BUILDING CODE OF AUSTRALIA COMPLIANCE ASSESSMENT REPORT

C2 – IVANHOE VILLAGE & COMMUNITY CENTRE

IVANHOE ESTATE – LOT C2, EPPING ROAD, MACQUARIE PARK

DATE ► 05/08/2021

A-A-102

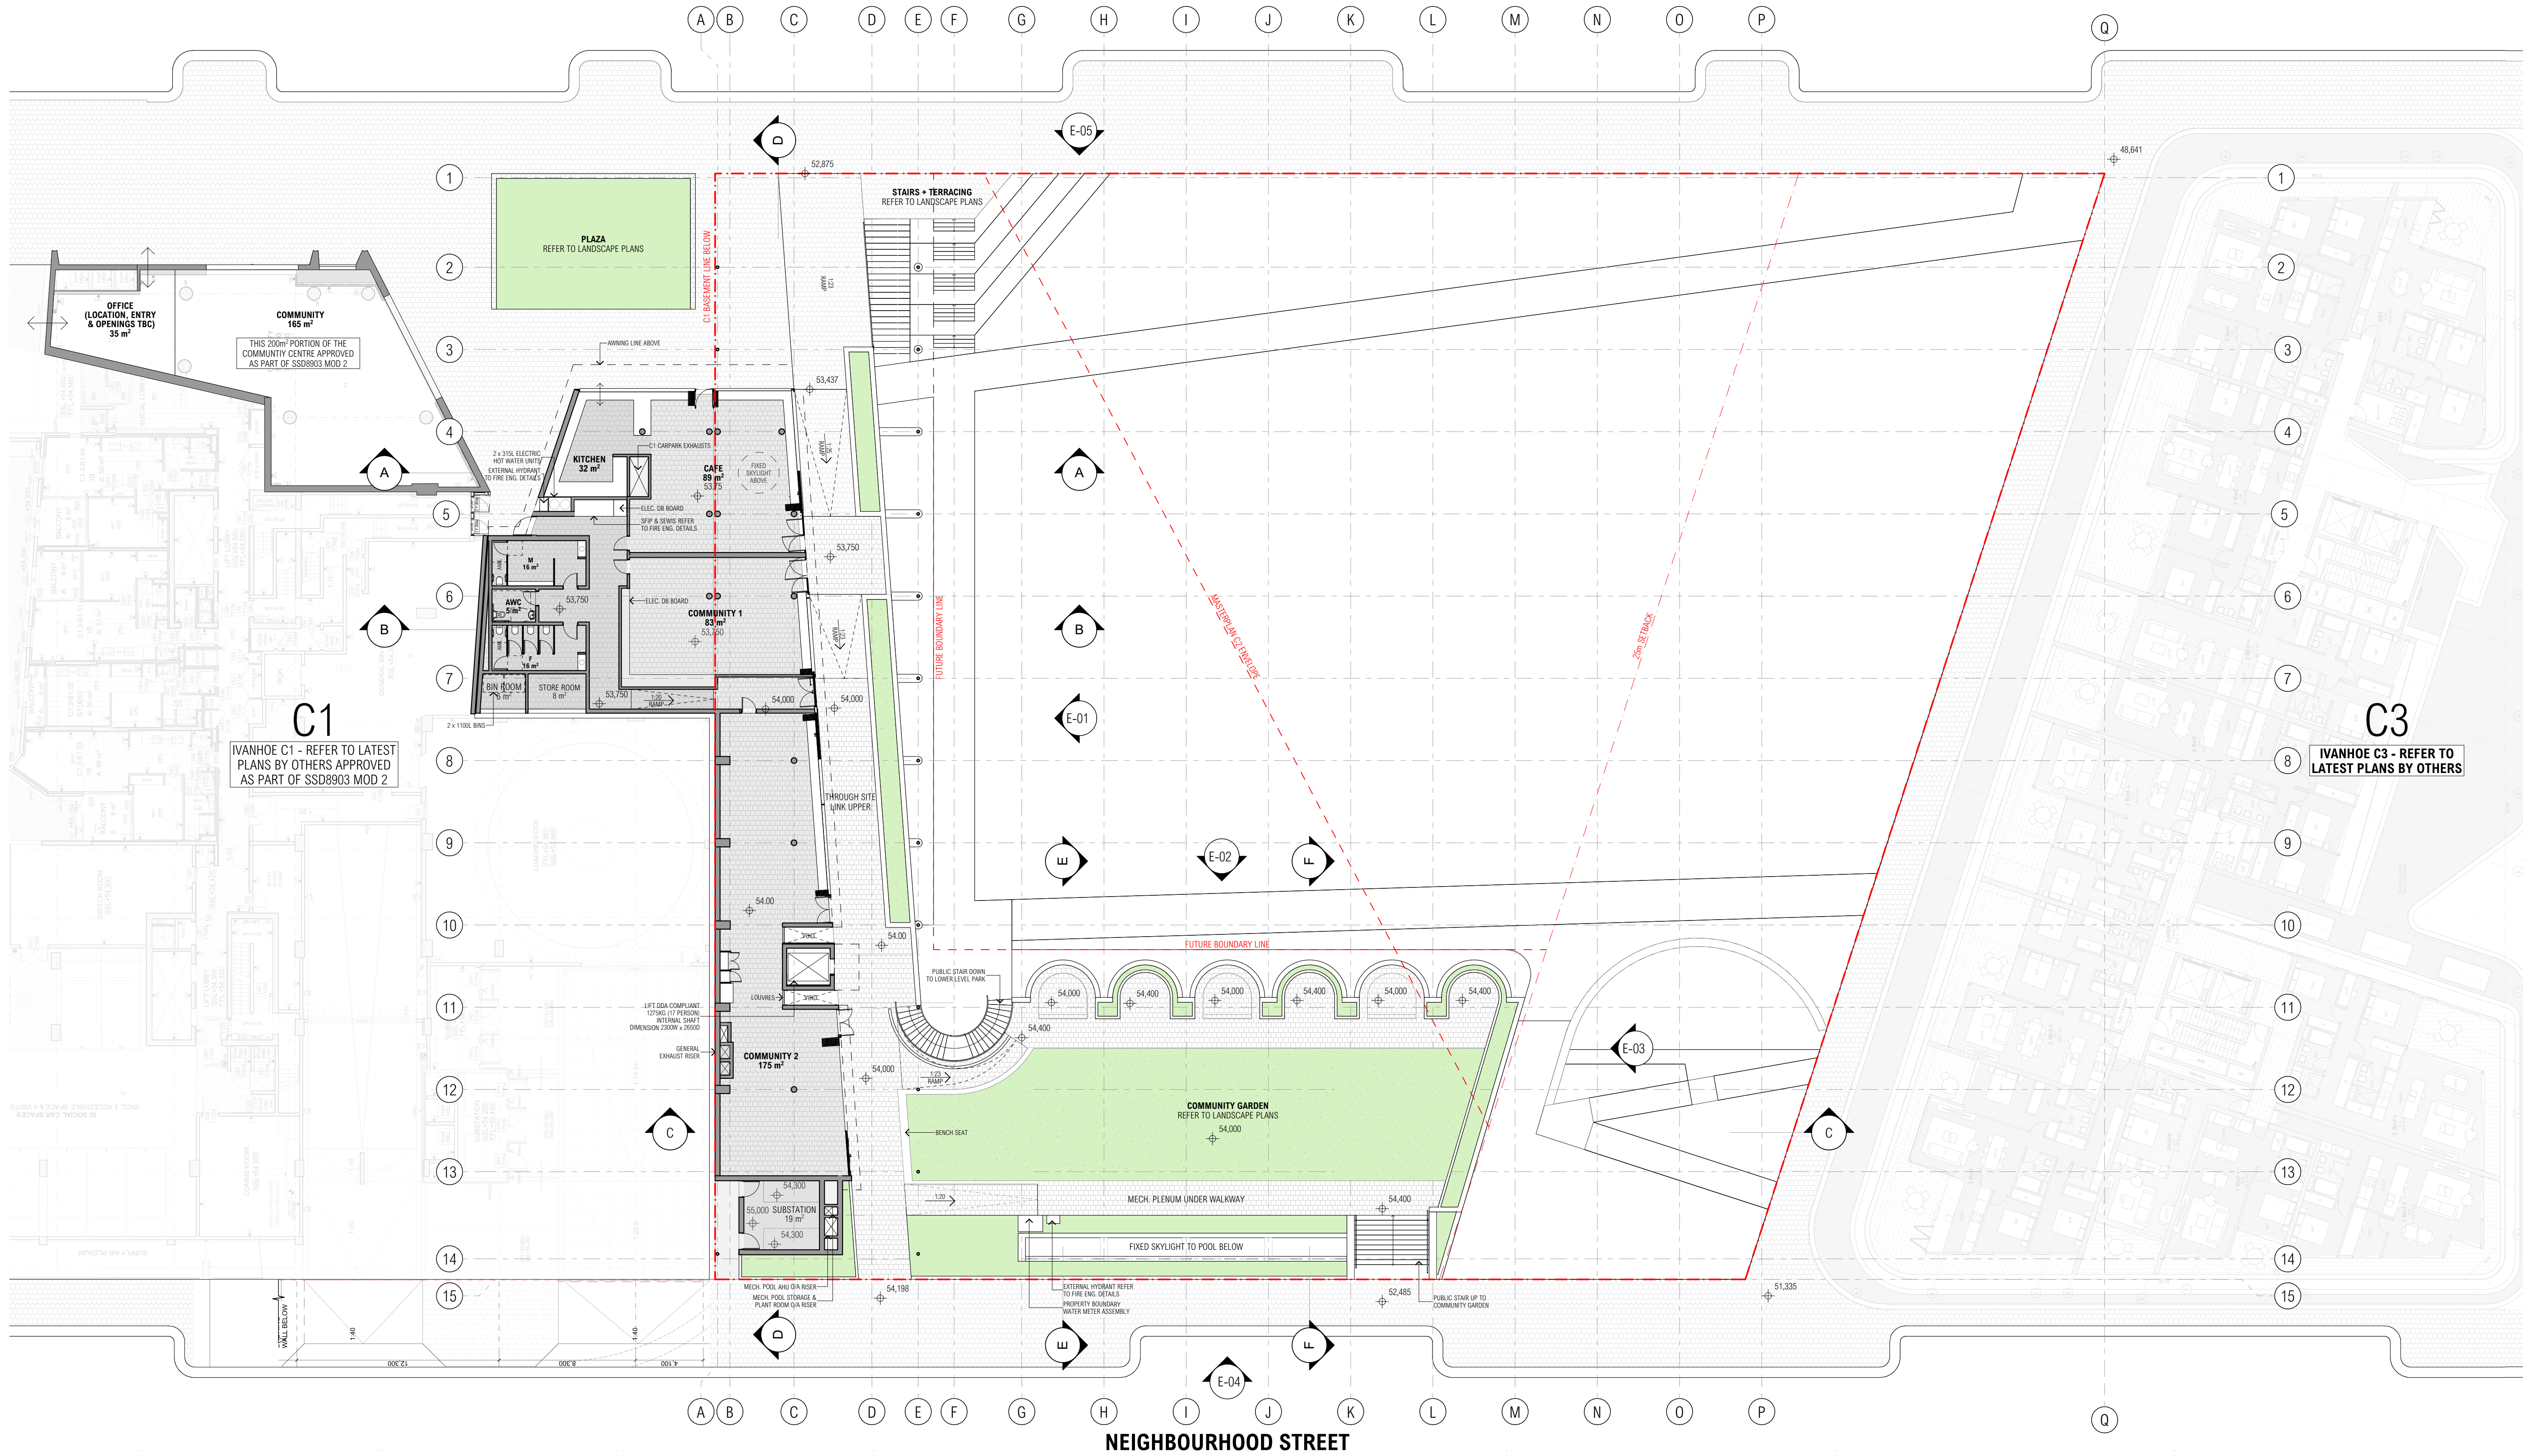
D2.20 Swinging Doors	<p>Lower Ground – Gym doorway is required to swing in the direction of egress.</p> 
E1.4 Fire Hose Reels	<p>Architectural plans are required to detail the location of the required fire hose reels.</p>
